# OAKLANDS FARM SOLAR PARK

Schedule of changes to the draft Development Consent Order  
August 2024

Document Ref: EN010122/D3/3.4

## Table of Amendments to the draft Development Consent Order Deadlines 1 and 3

Important Hedgerows Plan

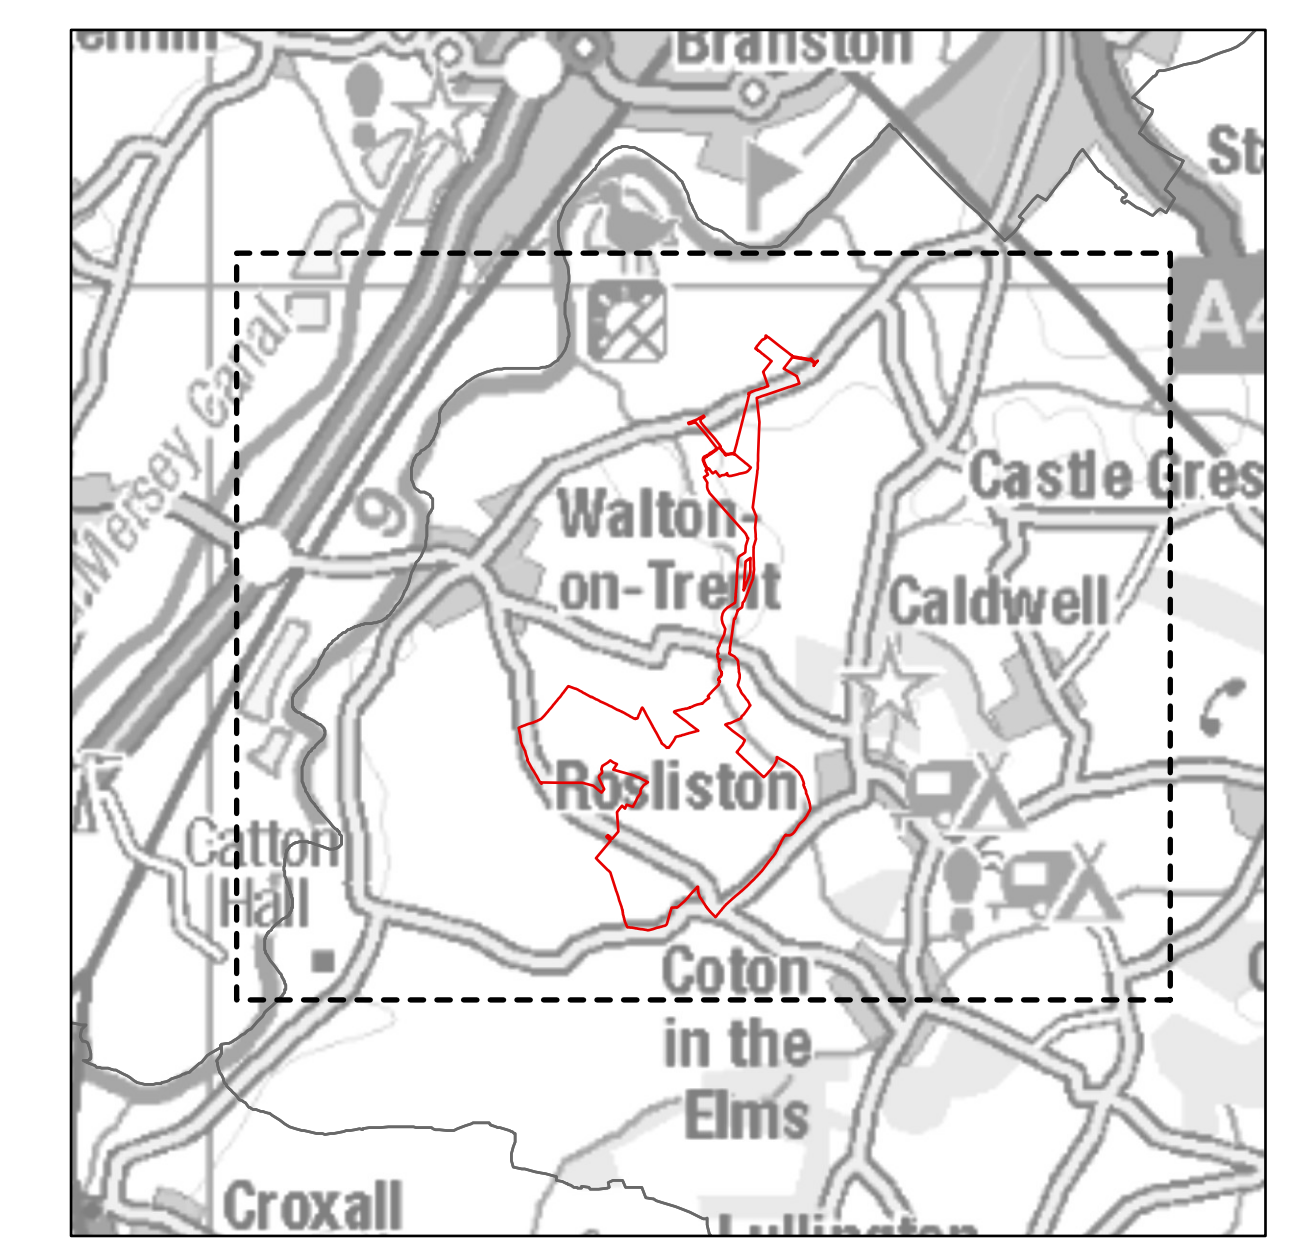
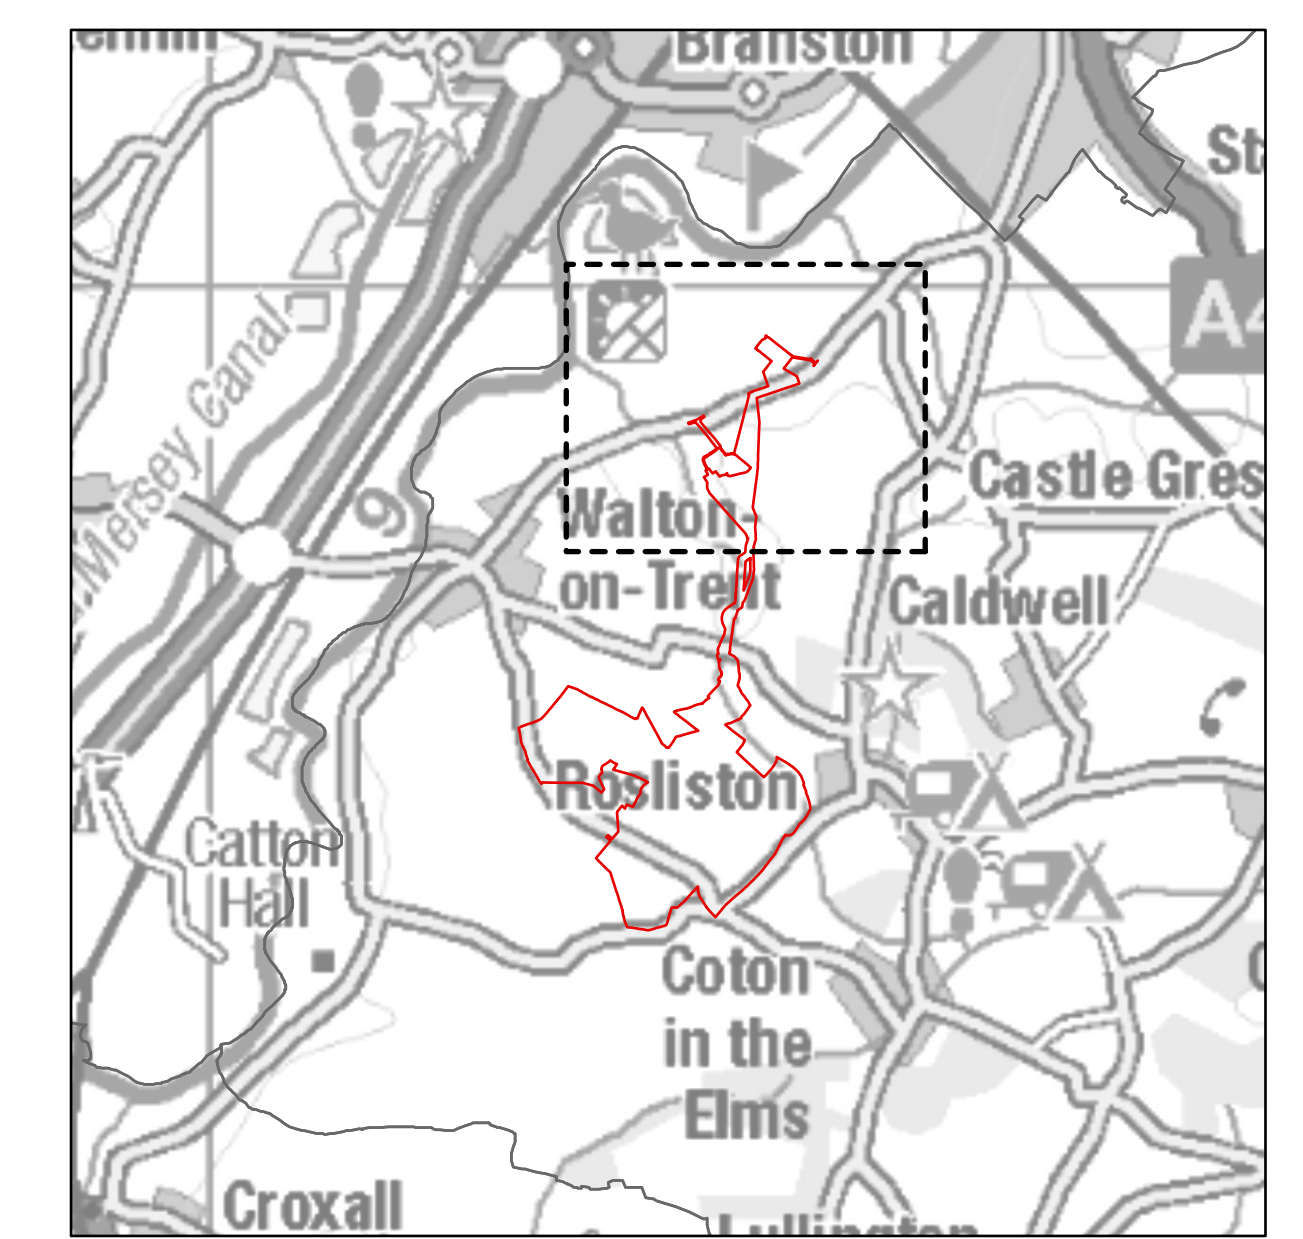
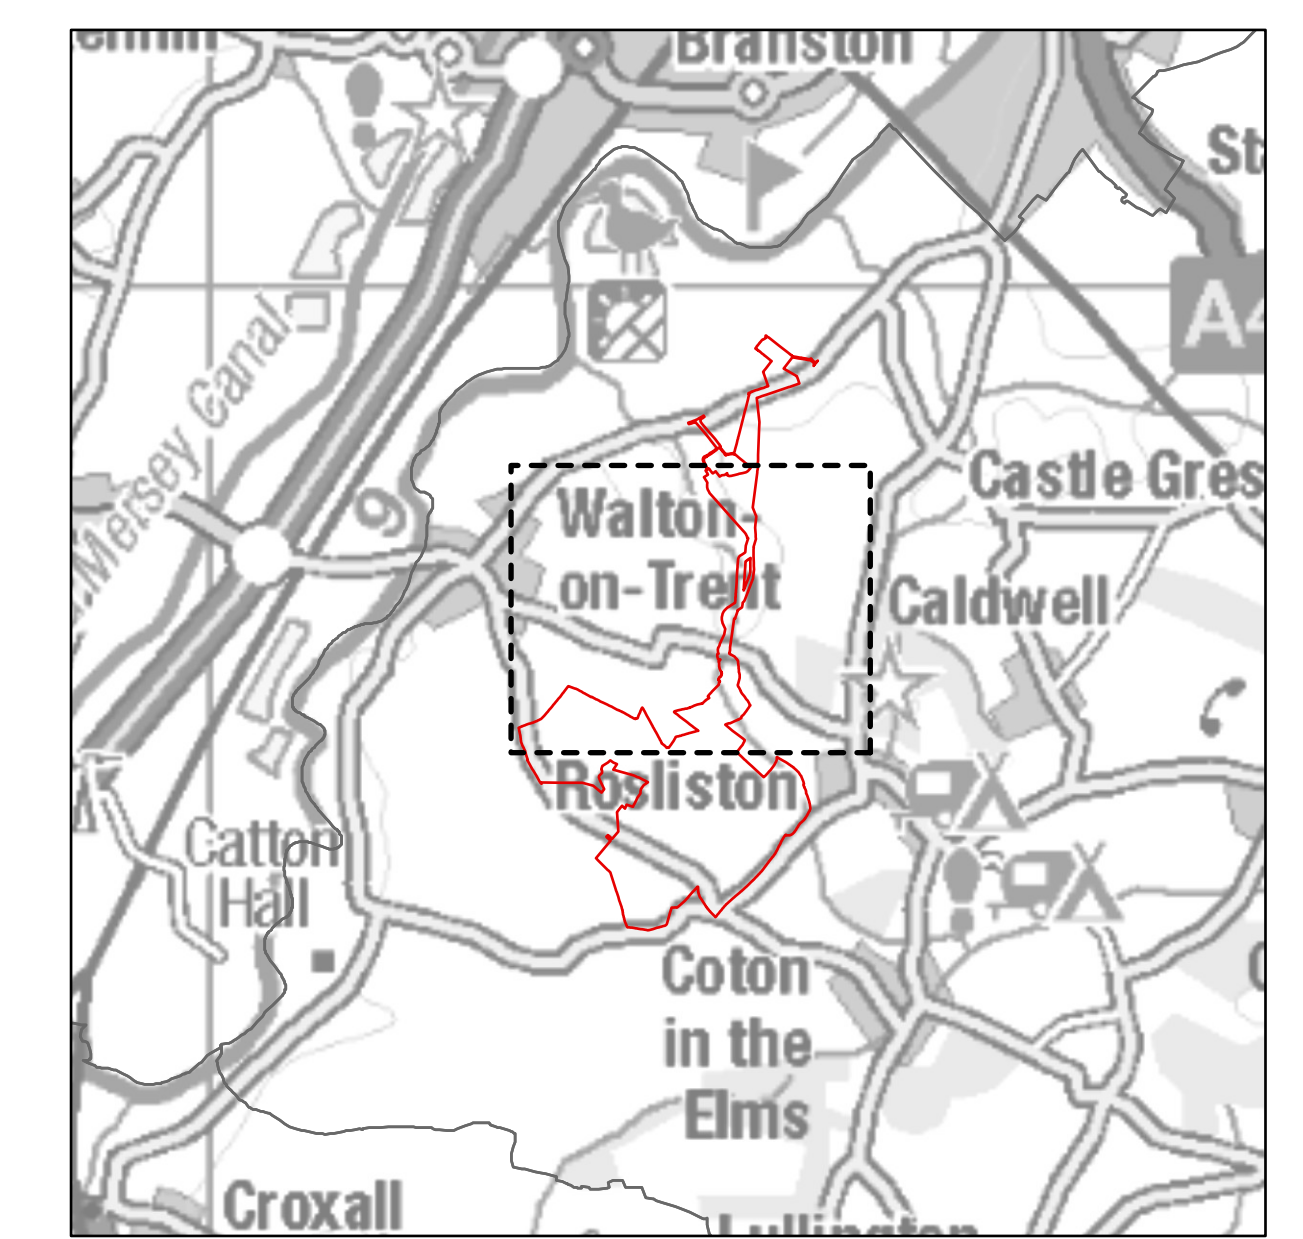
<b>Article 35(1)</b>	The description of the plan at Article 35(1)(b) has been updated to “important hedgerows plan”.  The reference to the “archaeological management plan” has been removed.	To correct drafting errors.
<b>Schedule 1, Part 2, R4(2)</b>	The words “The scheme submitted pursuant to sub-paragraph (1) must include a timetable for the construction of the phases of the authorised development and a plan identifying the phasing areas” have been added.	As explained in the Applicant’s Deadline 1 submission and its response to ExQ 1.8, this paragraph has been added to Requirement 2 to prescribe that the written scheme setting out the phases of construction of the authorised development to be submitted and approved under sub-paragraph (1) includes a timetable for the
